# Former Nestlé Factory – Waste and Recycling Response Note

AECOM have produced this Waste and Recycling Response Note (hereafter referred to as 'the Note') in order to address the comments received from the London Borough of Hillingdon (LBH) (REF JR/MK/BB dated 13/10/2017) regarding the May 2017 Operational Waste and Recycling Management Strategy (hereafter referred to as the 'Strategy') submitted in support of the Former Nestlé Factory development (hereafter referred to as 'the Proposed Development') (REF 1331/APP/2017/1883). The responses to the comments received from the LBH are detailed below.

WASTE AND SERVICES LAYOUT - GROUND FLOOR PLAN

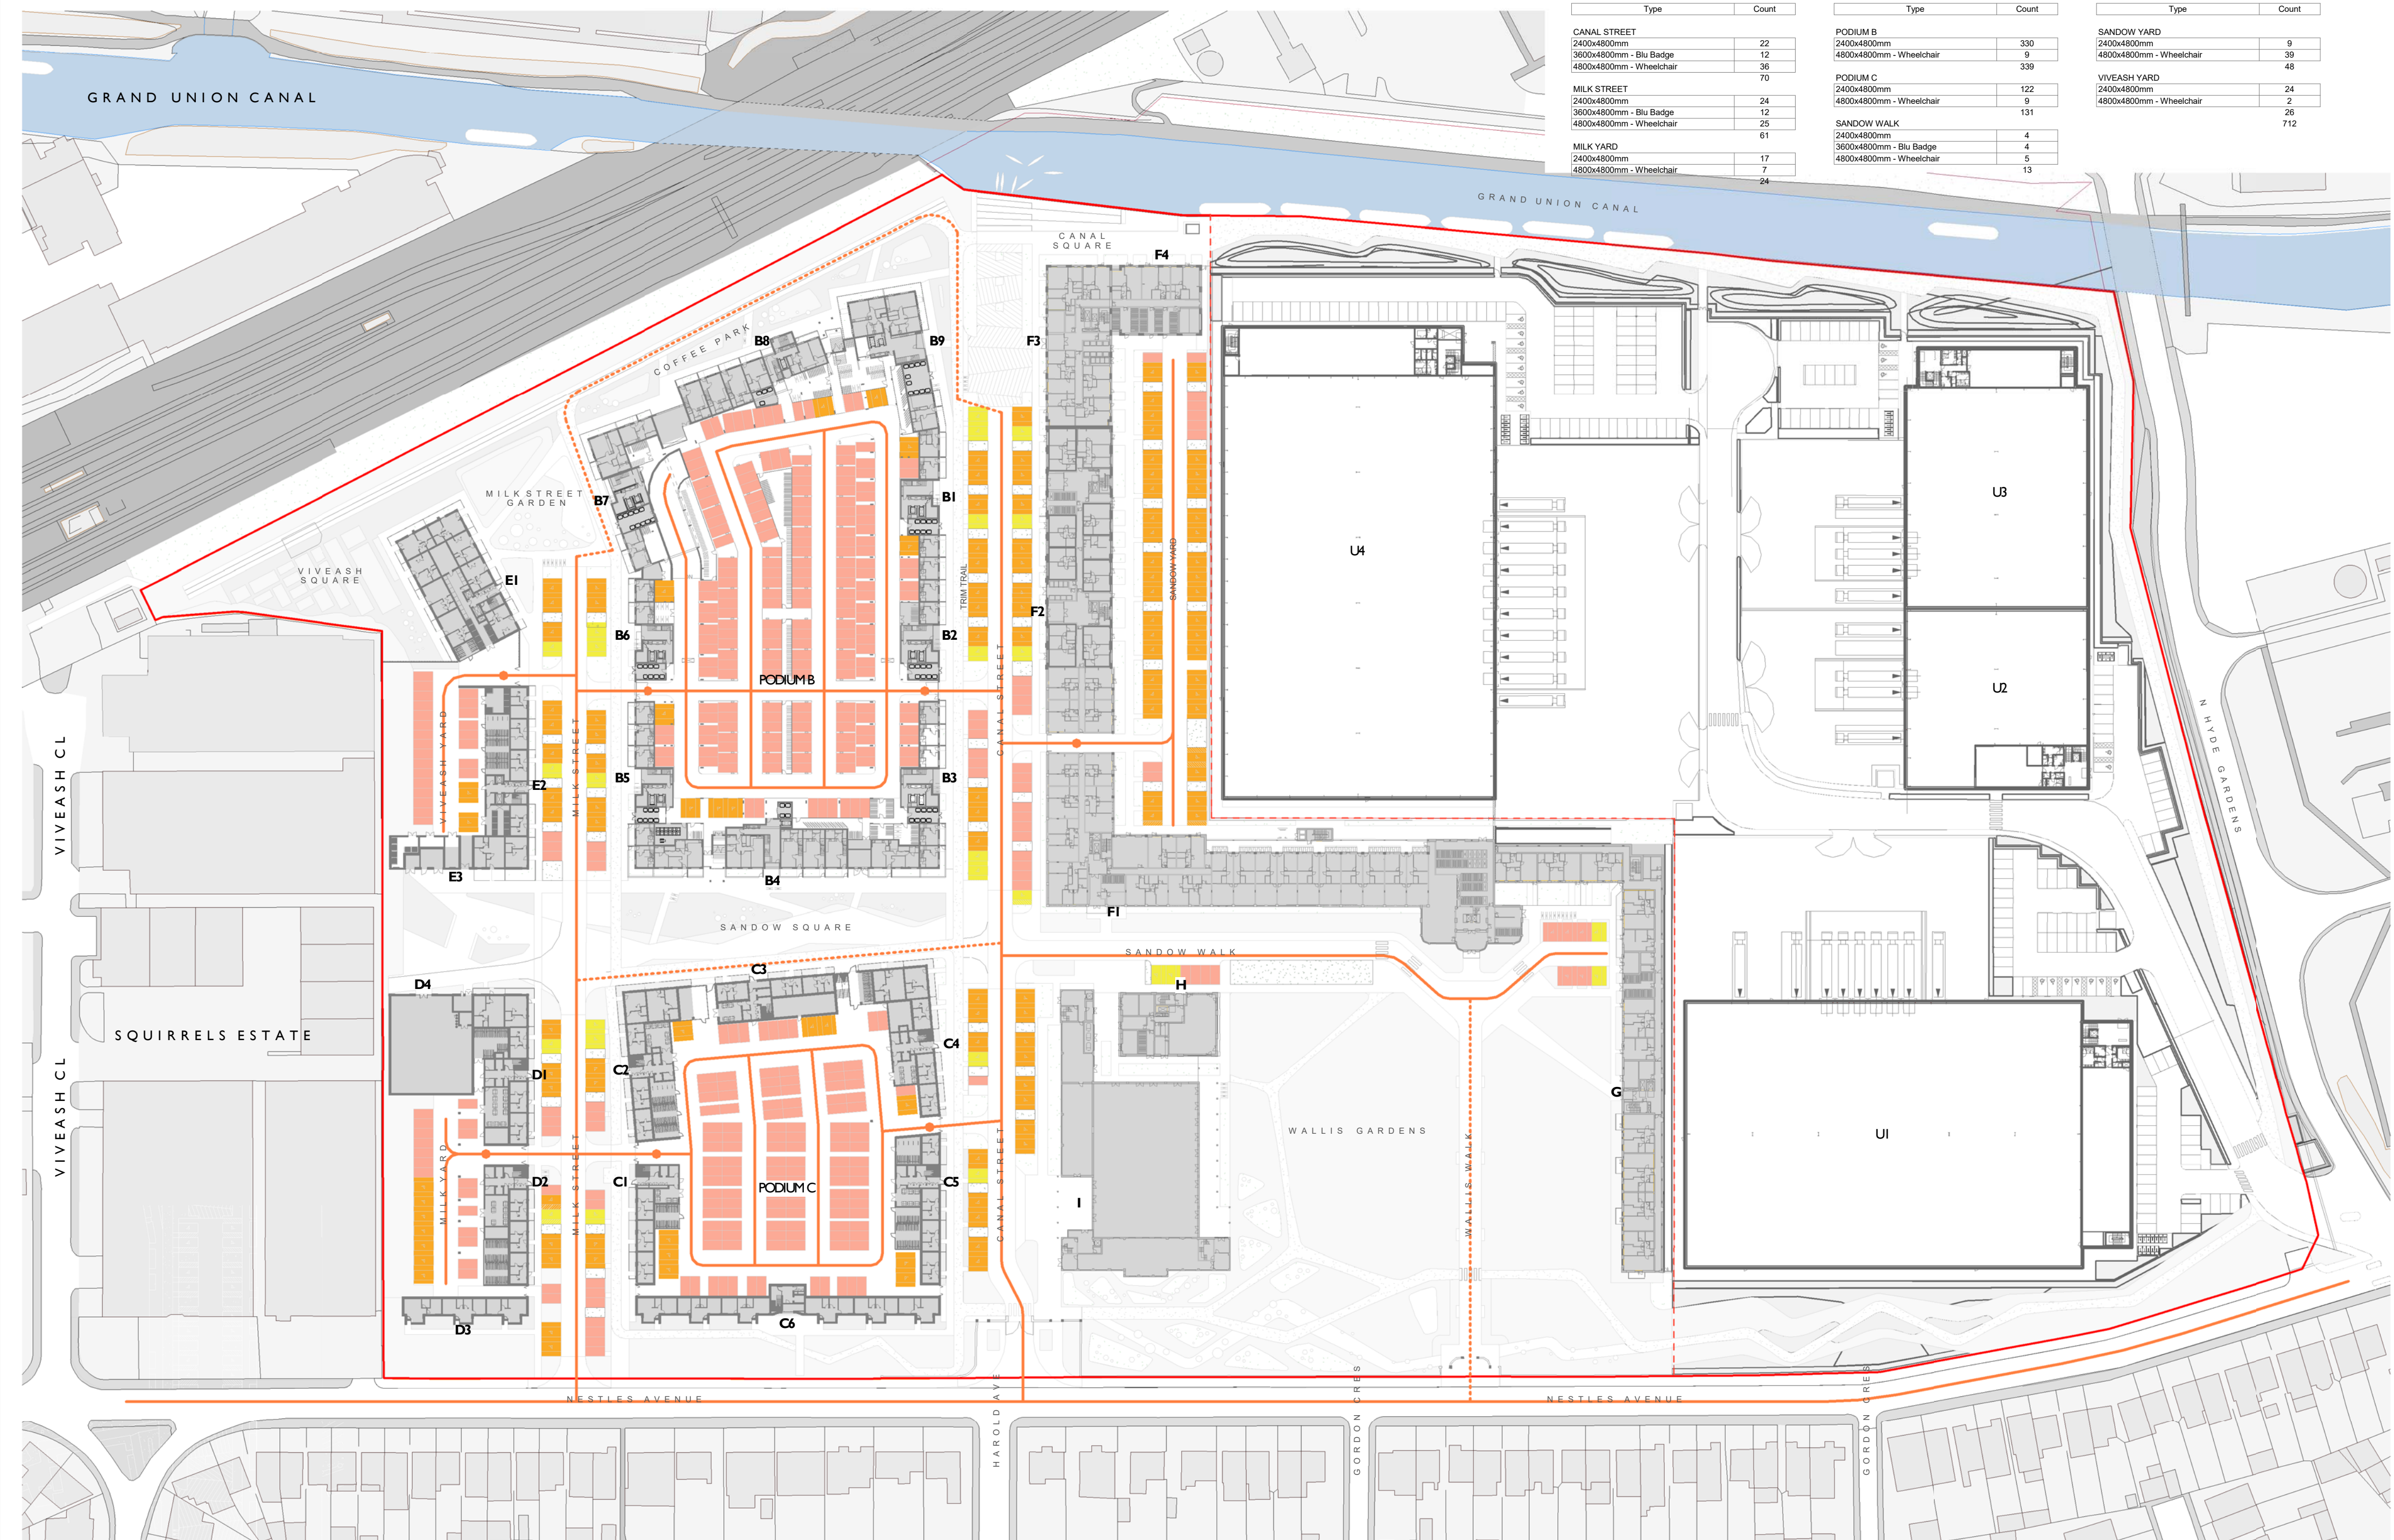
*'Another issue is with the 'Waste Presentation Areas', where bins will be moved to and from the bin storage areas by management on collection days. These are located in sensitive locations particularly the one in Wallis Gardens directly in front of the main façade of the factory building. The Council needs convincing that the locations of these Waste Presentation Areas will not impact on the character of the area or undermine the proposals in anyway. The capacity of the Waste Presentation Area is 89 Euro Bins in total, whereas the residential scheme currently proposed 192 Euro Bins (this will rise to 204 Euro Bins as per comments above). Can you please clarify how the rest of the bins will be collected and update the submission as required.'*

In terms of this comment, the waste presentation areas will be stringently managed by the internal management team. Once the Proposed Development is operational, an allocated time slot will be provided for collection. Prior to collection the bins will be hidden from view within the waste stores. On the day/time of collection, the internal management team will bring the bins for the appropriate waste stream out for collection through the use of vehicle tugs. Once emptied the internal management team will transfer the bins back to the appropriate stores using the vehicle tugs and as a result the bins will be on display for a short period of time only. The bins will not be placed within the presentation areas for longer periods than required, minimising the impact on the character of the area. In addition, it is envisaged that waste will be collected during anti-social hours such as early in the morning which will further limit the amount of people who will pass these areas and limit the impact upon local amenity.

As a part of the design process, the waste presentation areas were reduced from two large presentation areas to five smaller presentation order in order to reduce the visual impact of these areas and protect the character of the Site. In addition, the bins will be placed onto the multiple-use hardscaped areas within the public realm. These have been designed to be non-intrusive as not to detract from the amenity value and useable space. The waste presentation areas will be cleaned after use as to allow this space to remain as a primarily usable space.

In terms of the size of the waste presentation areas, in a telephone conversation with the Waste Development Manager, it is understood that the mixed dry recyclable (MDR) and residual waste streams are collected separately. Therefore, within the waste presentation areas, sufficient space will need to be provided for half of the bins only i.e. 96 x 1,100L Euro Bins. The waste presentation areas have been updated on the plans to accommodate 96 x 1,100L Euro Bins, please refer to Appendix C.
